**Modification of Residential Subdivision
Lot 5 DP 788159, The Park Drive, Sanctuary Point**

Please find below Council's detailed submission to the proposed s. 75W modification to approved residential subdivision DA 485-12-2002.

Submission to DA 485-12-2002 MOD 1: 50 Lot Residential Subdivision Nadine St, Sanctuary Point

TYPICAL 5m ROAD 01 CROSS SECTION
SCALE 1:50

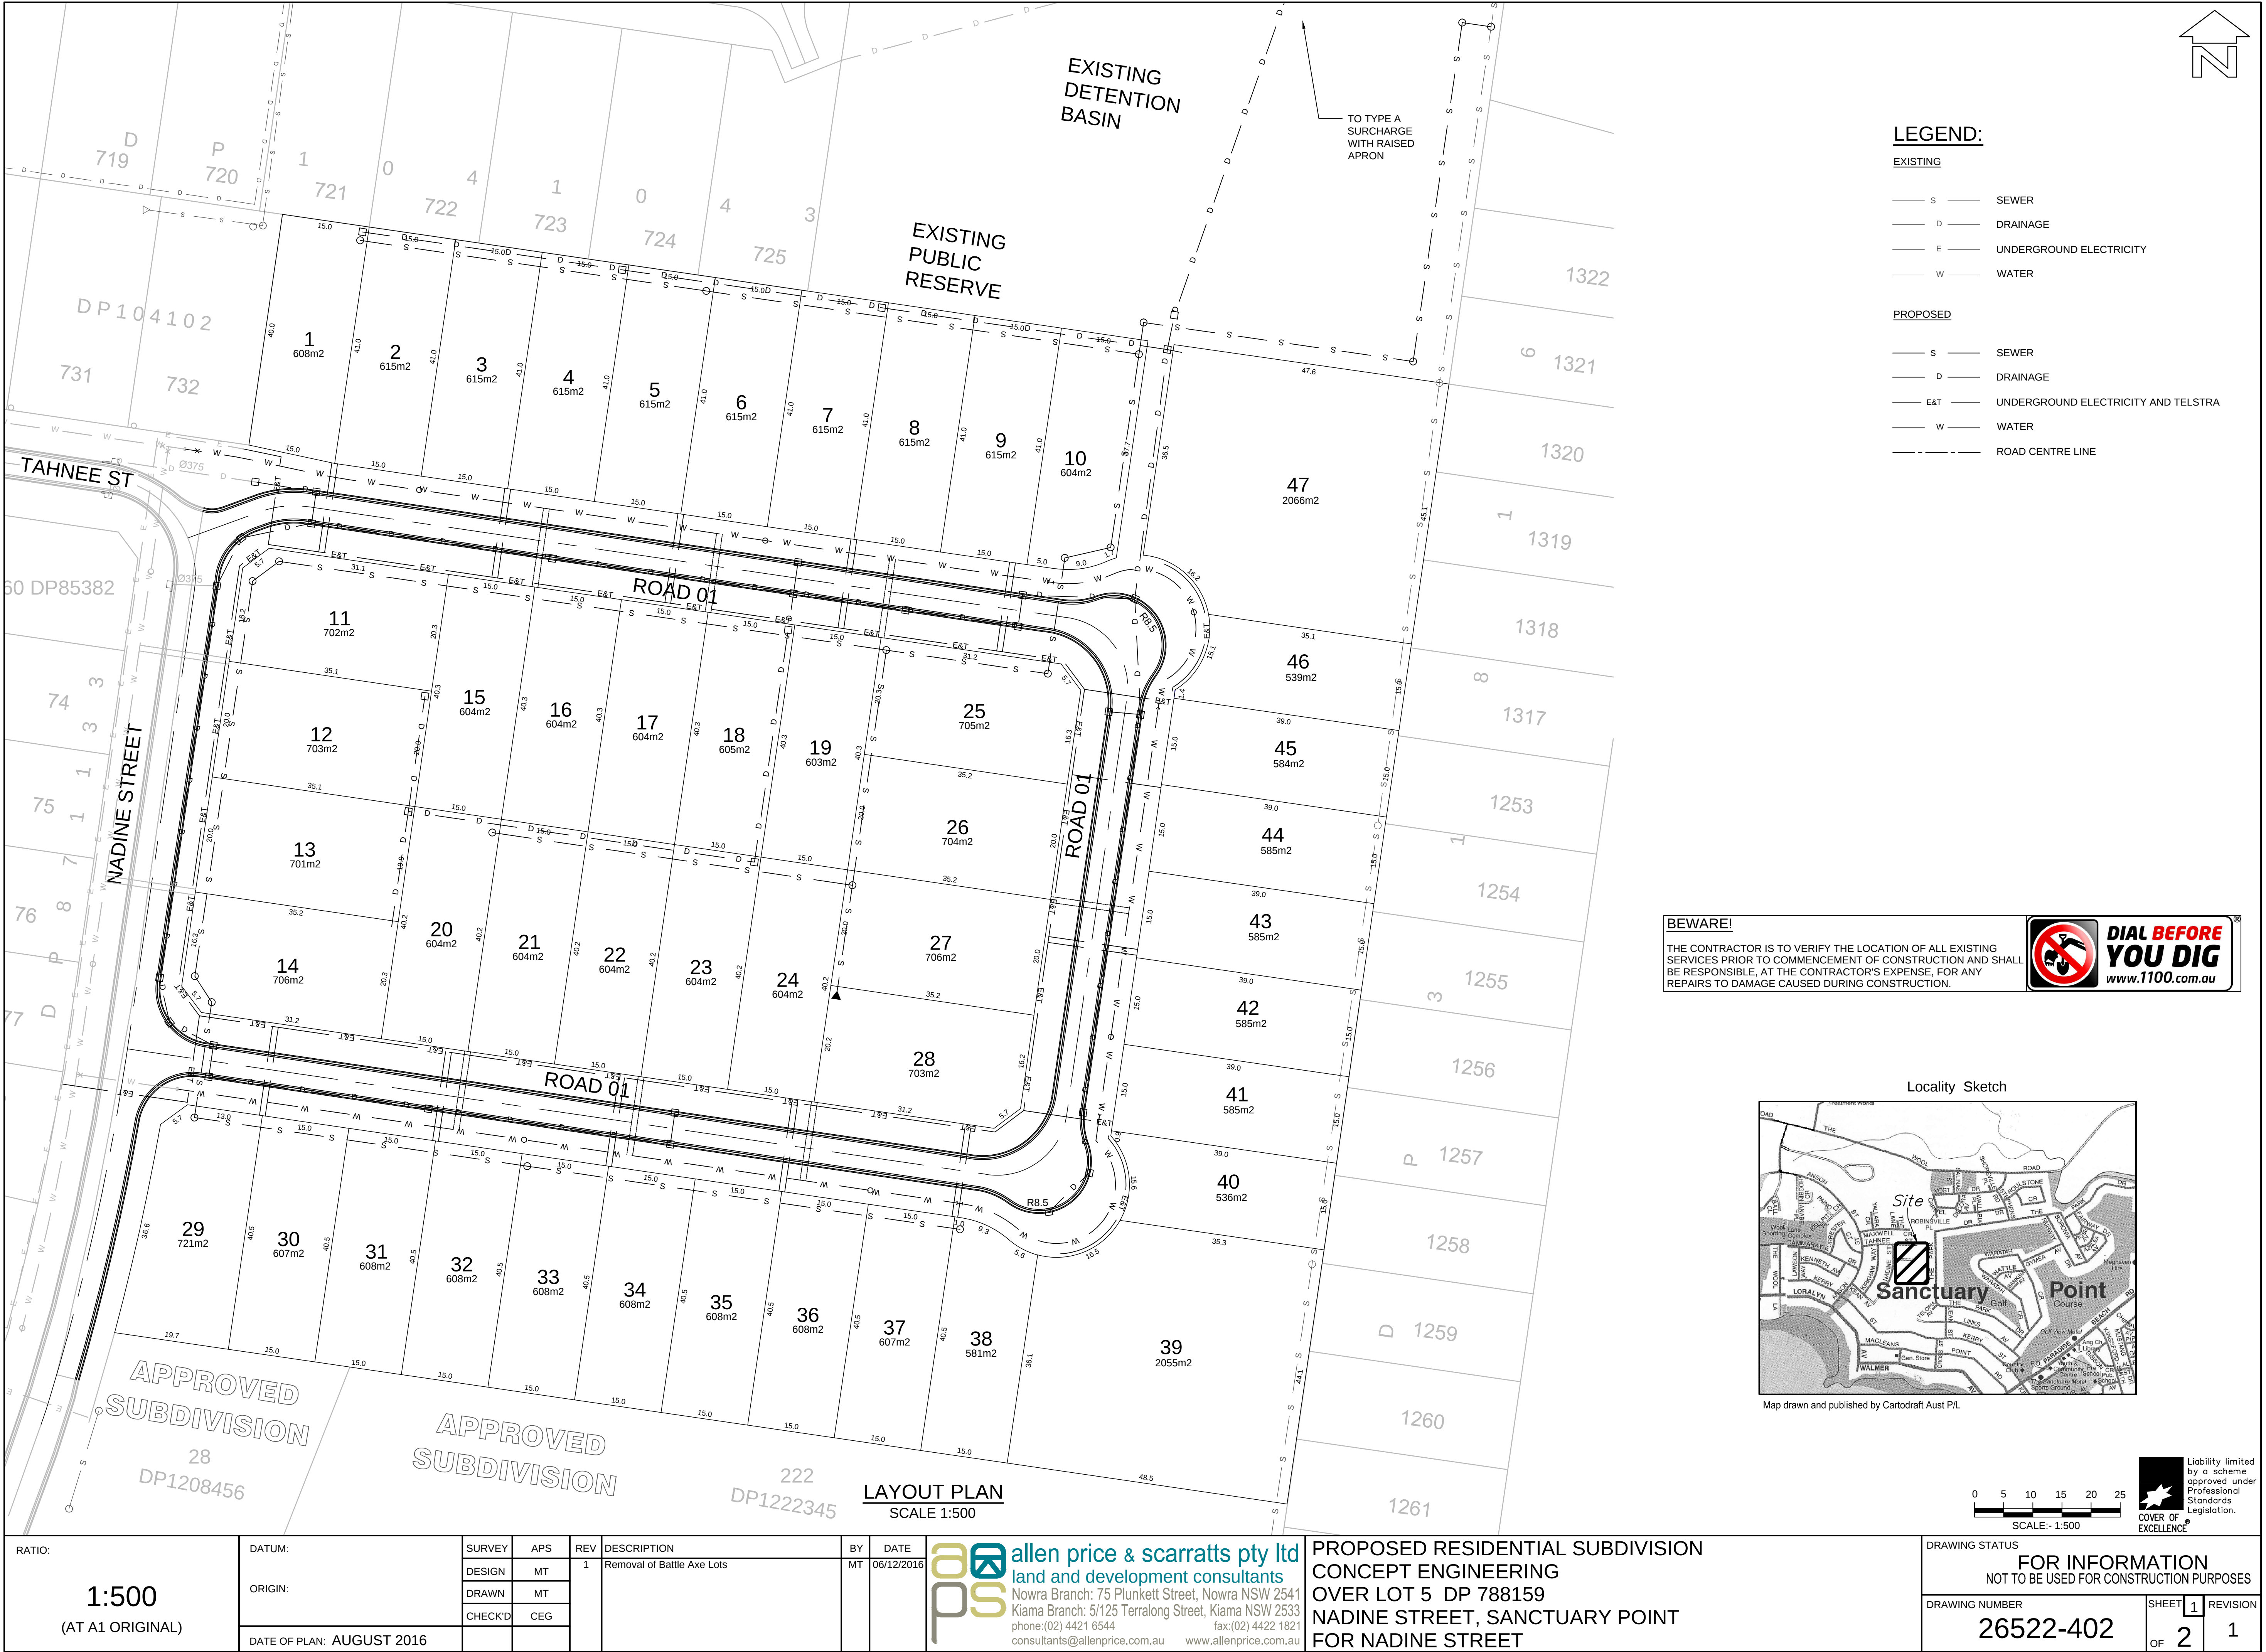
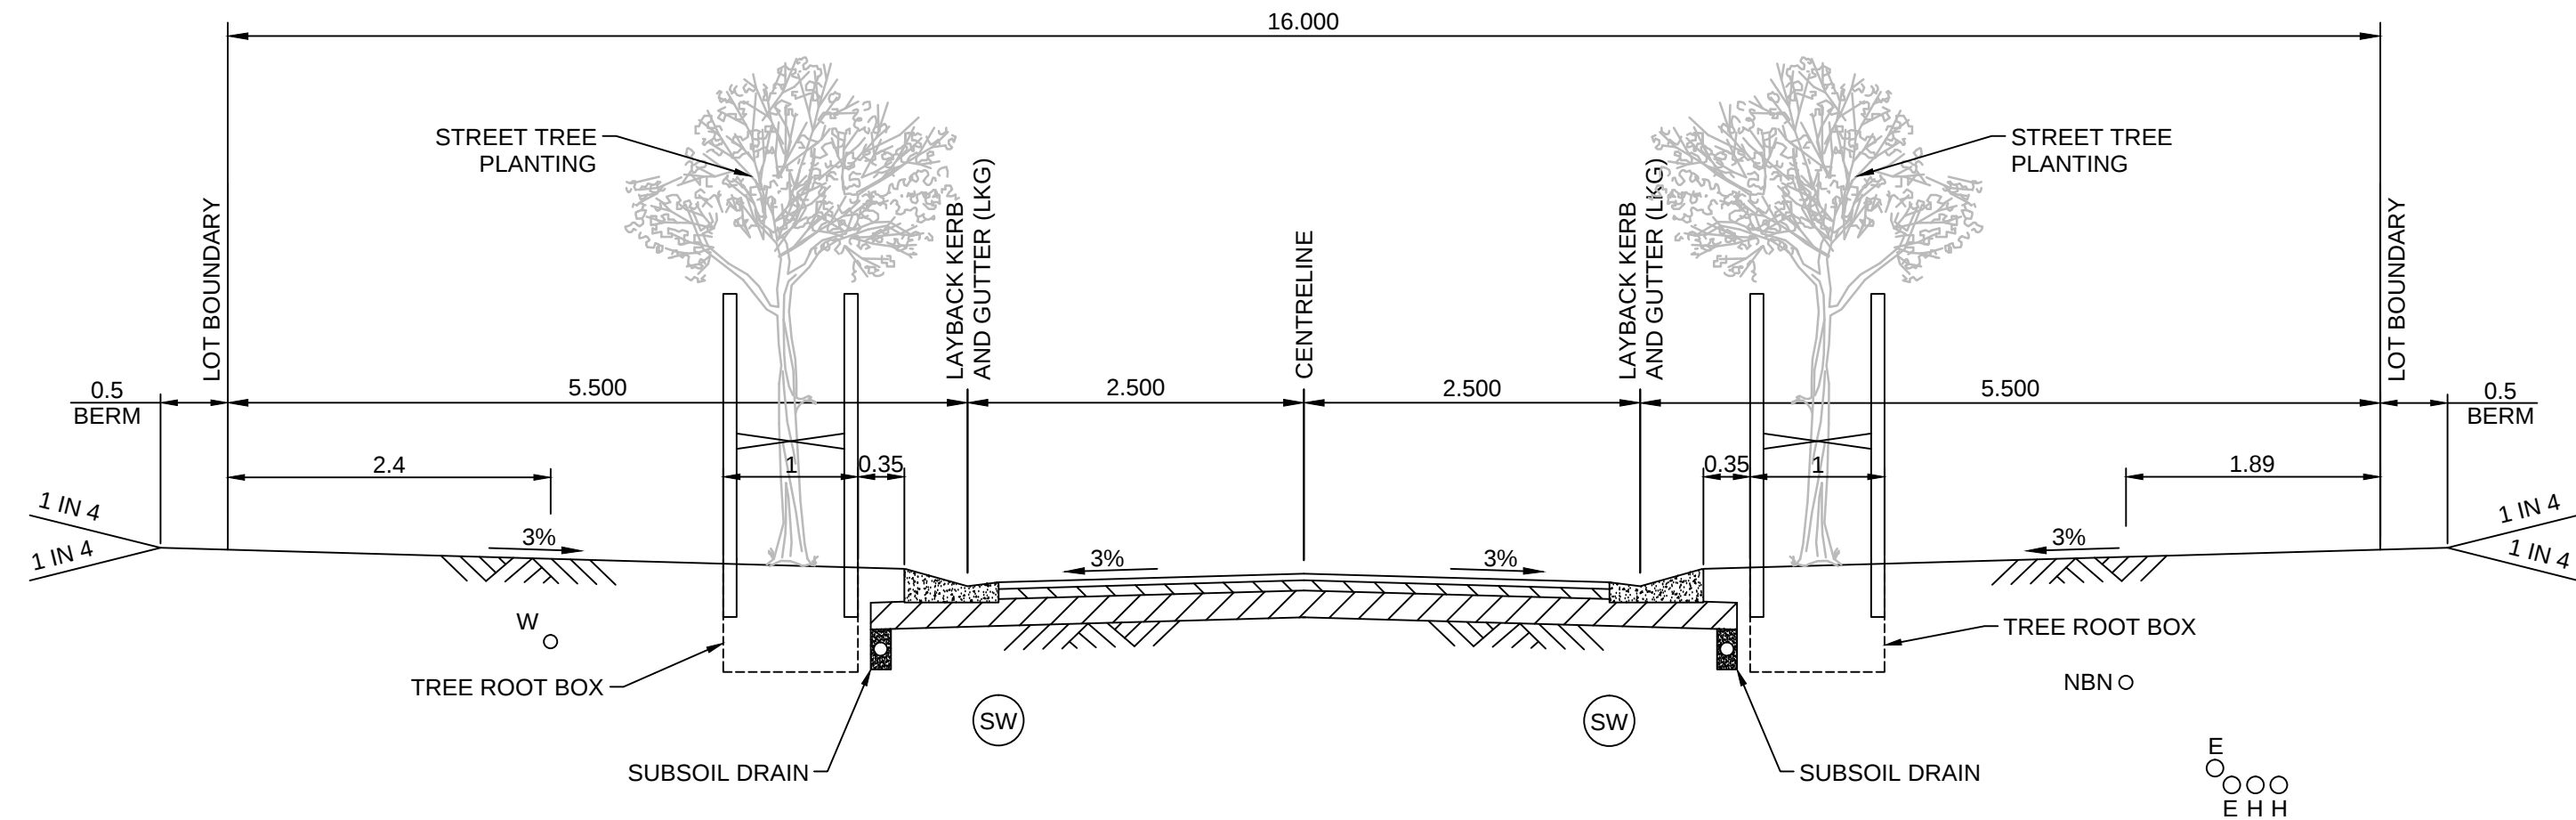
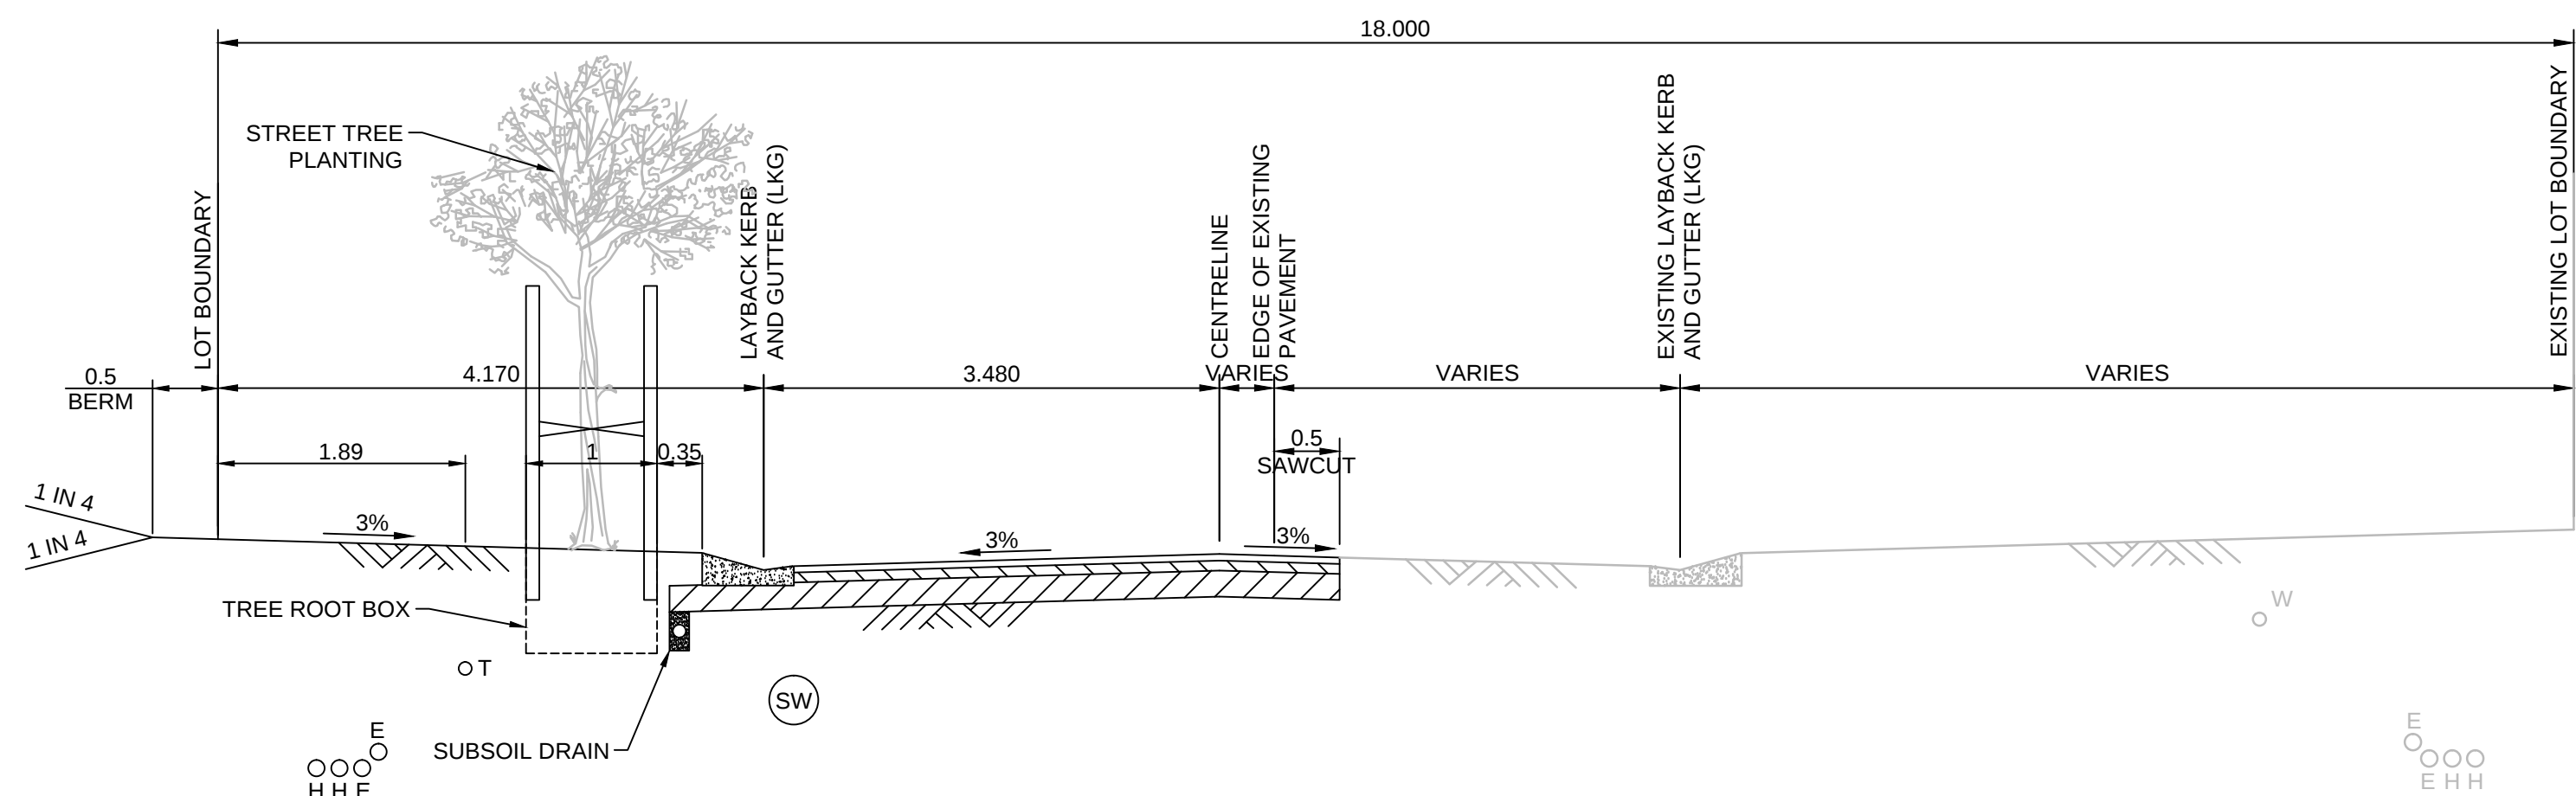
The road reserve widths proposed for the north and south legs are less than the original approval of 18m and are now proposed at 16. The applicant has not advised of the proposed roadway and verge widths or proposed “knuckle” radii. The original road reserve at the eastern end with the narrow roadway may have been 16m but the approved plans make no mention of it. The current proposed plans indicate unusual widths for the verge and roadway widths at Nadine St and the road reserve appears to be 16m as well therefore typical cross sections will be required for all roads.

Council has been requested in the past to reconsider the location of street trees installation following provision of underground services not leaving sufficient suitable space. To ensure this does not occur again and allow Council to suitably assess any application, we need typical cross sections (see also comment above) to show proposed service and landscaping locations and confirm the proposed roadway and verge widths which are not dimensioned in the application.

TYPICAL DETENTION TANK

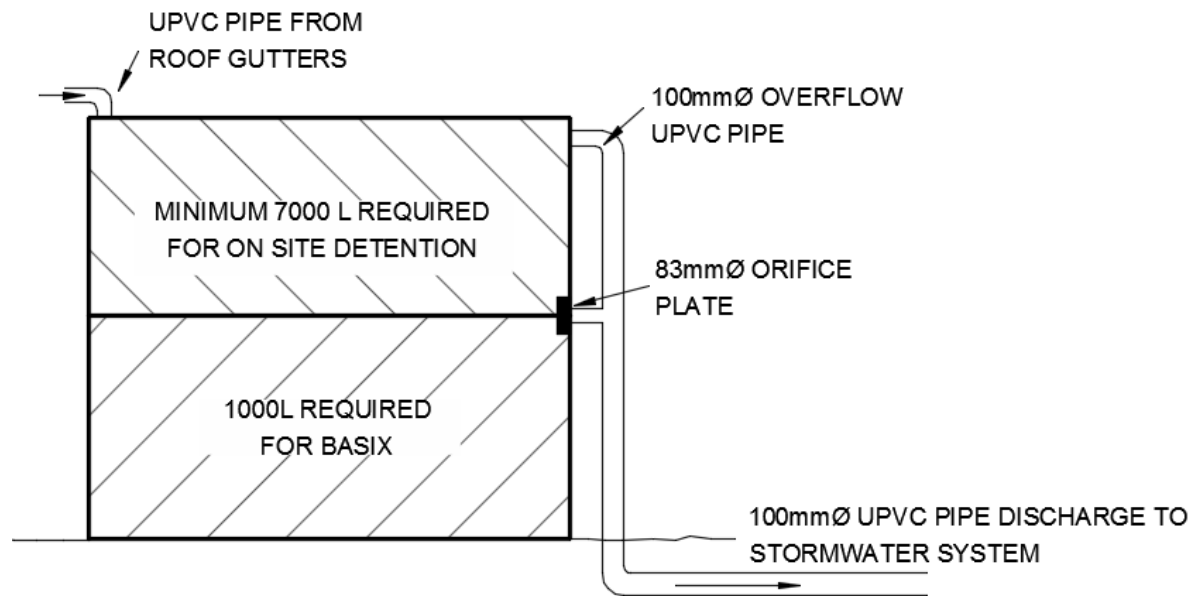
Deletion of the detention basin is to be compensated for by way of On-site Detention (OSD). Calculations for OSD demonstrating the effectiveness and application of this strategy have not been provided.

The applicant has not provided their calculations for the proposed onsite detention system with the application and we can't be sure if their S75w is compliant with their pre application discussions with Council. A copy of their calculations as discussed with Council prior to the S75W submission must be provided for confirmation by Council.
